Our Ref 600283-L002

RE: MEADOWBANK PRECINCT MASTER PLAN, SHEPHERDS BAY

Please find attached updated stormwater drainage concept drawings as requested.

Drawing Title : UPPER BASEMENT PLAN

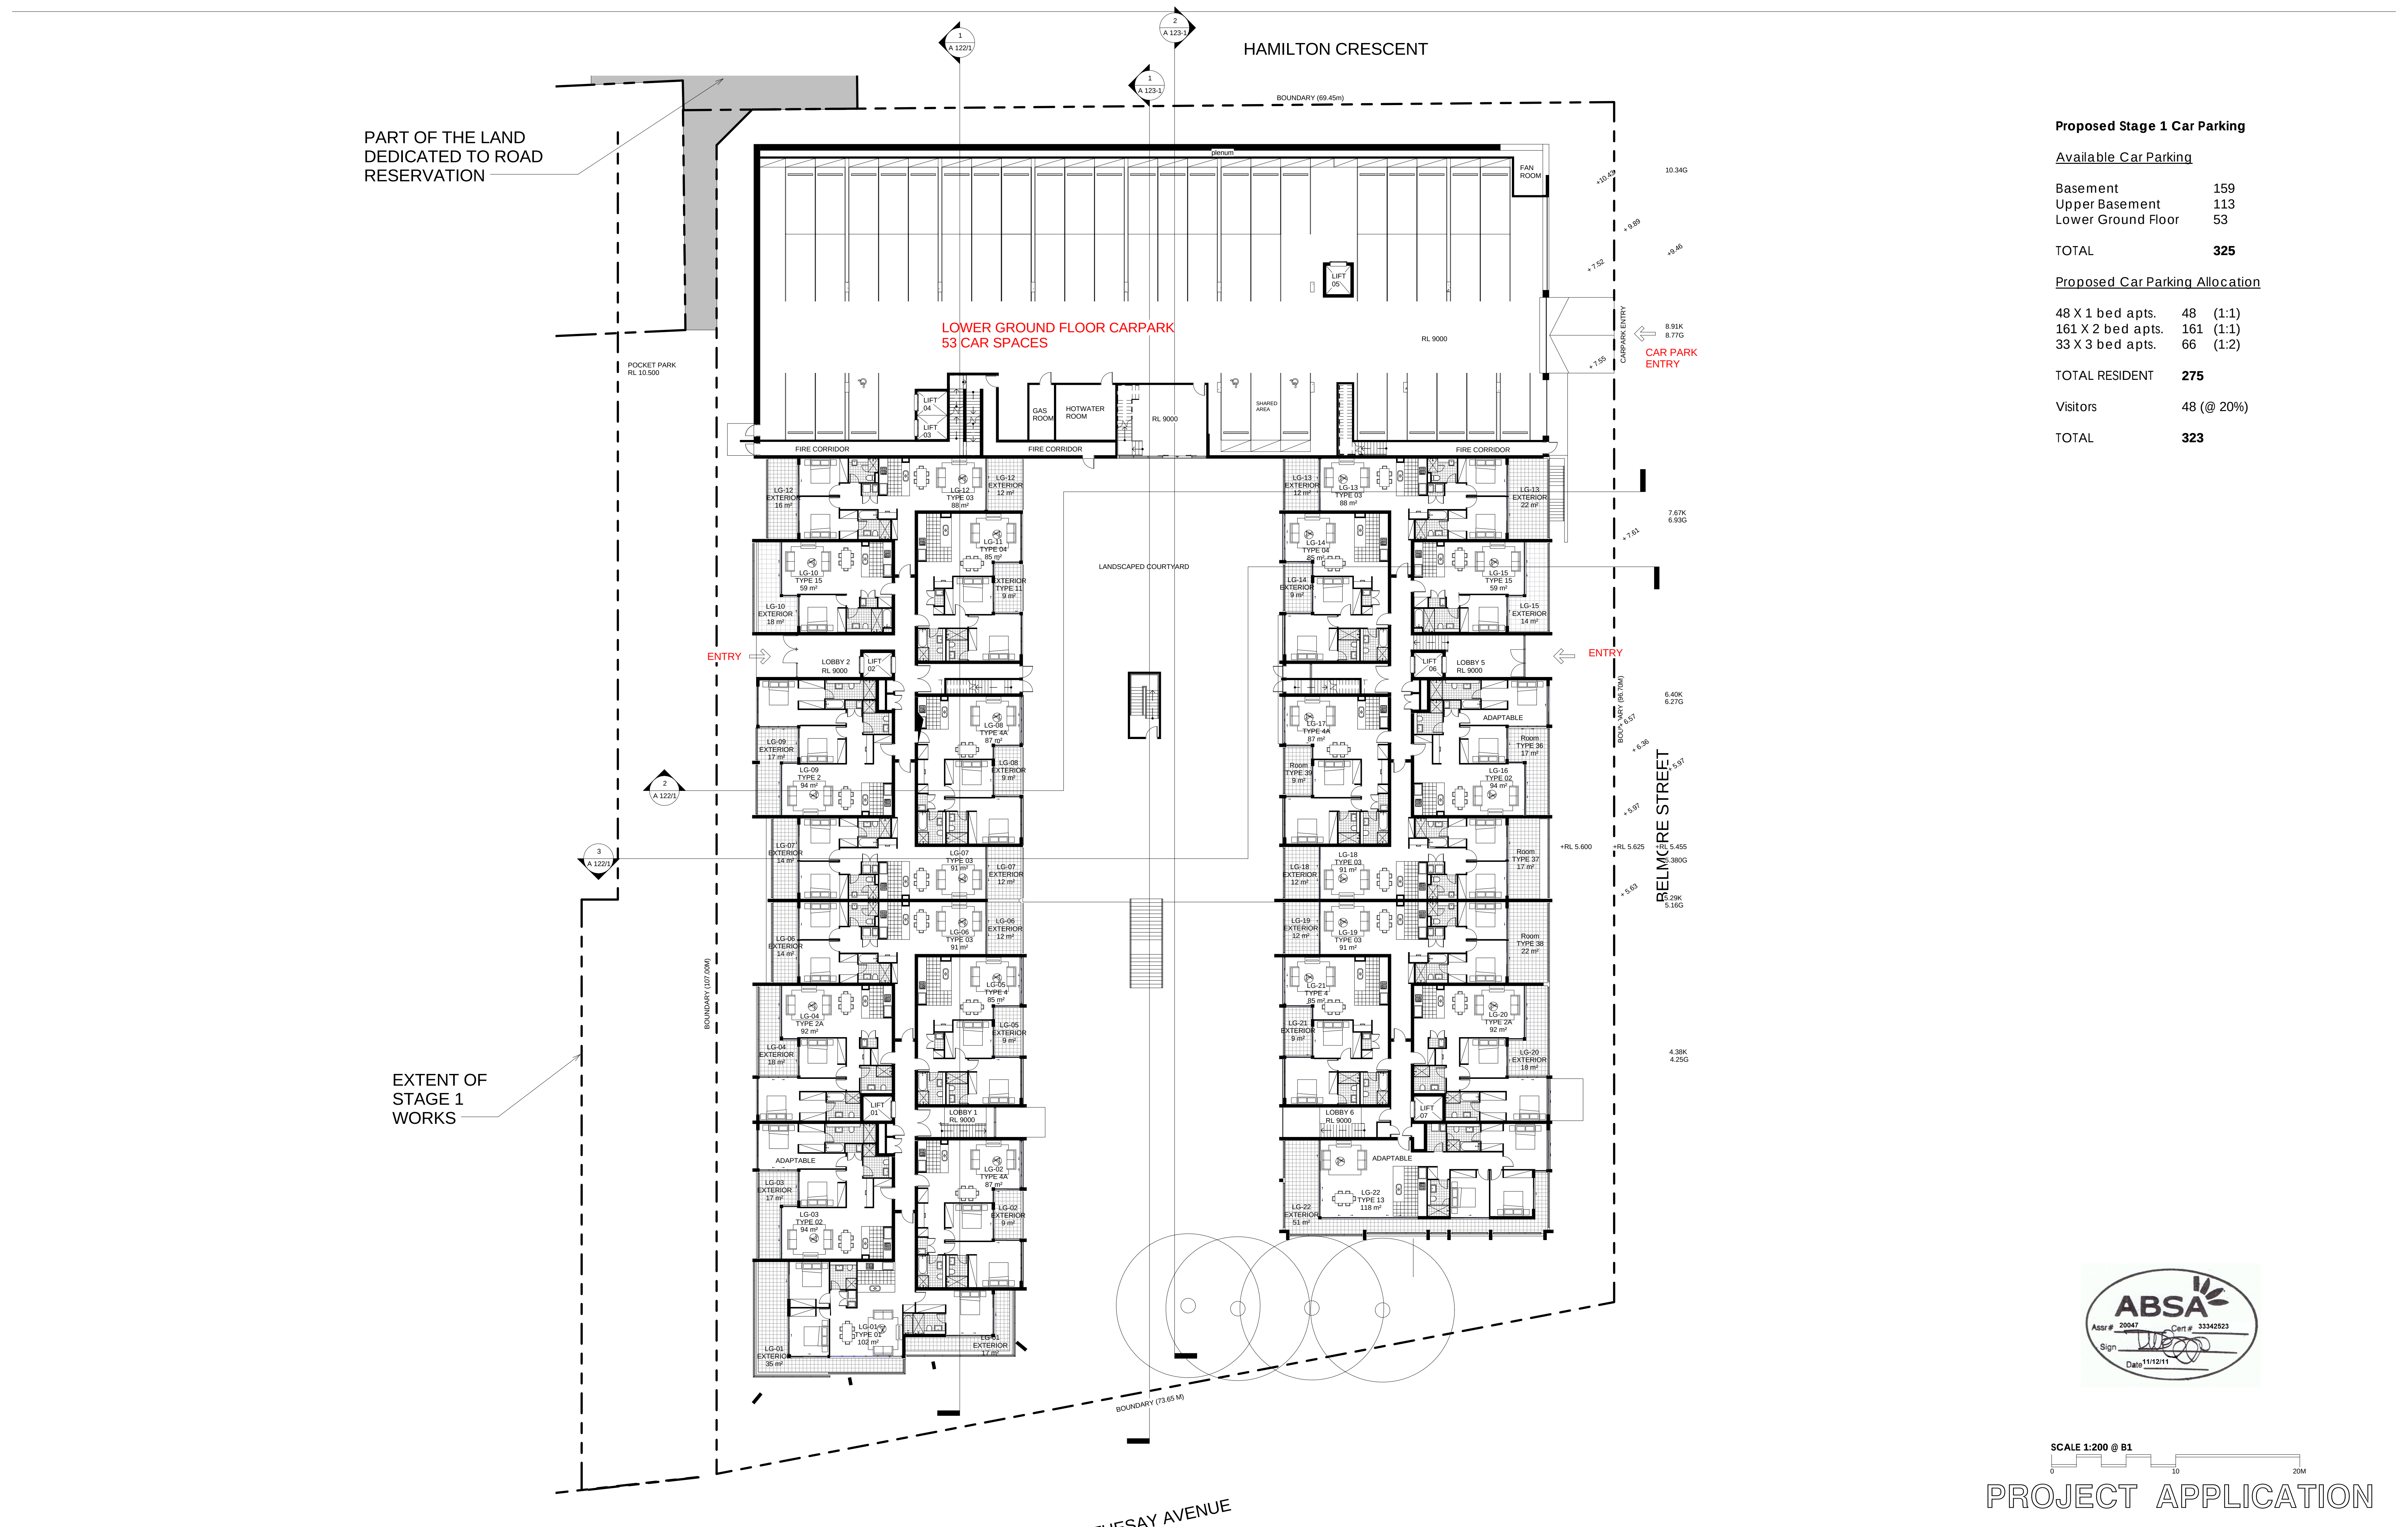
We confirm that the latest architectural layout changes have minimal impact on the overall site stormwater strategy. We note that the location of the rainwater tank shown under the upper basement vehicle ramp has been relocated to suit the amended location of the ramp.
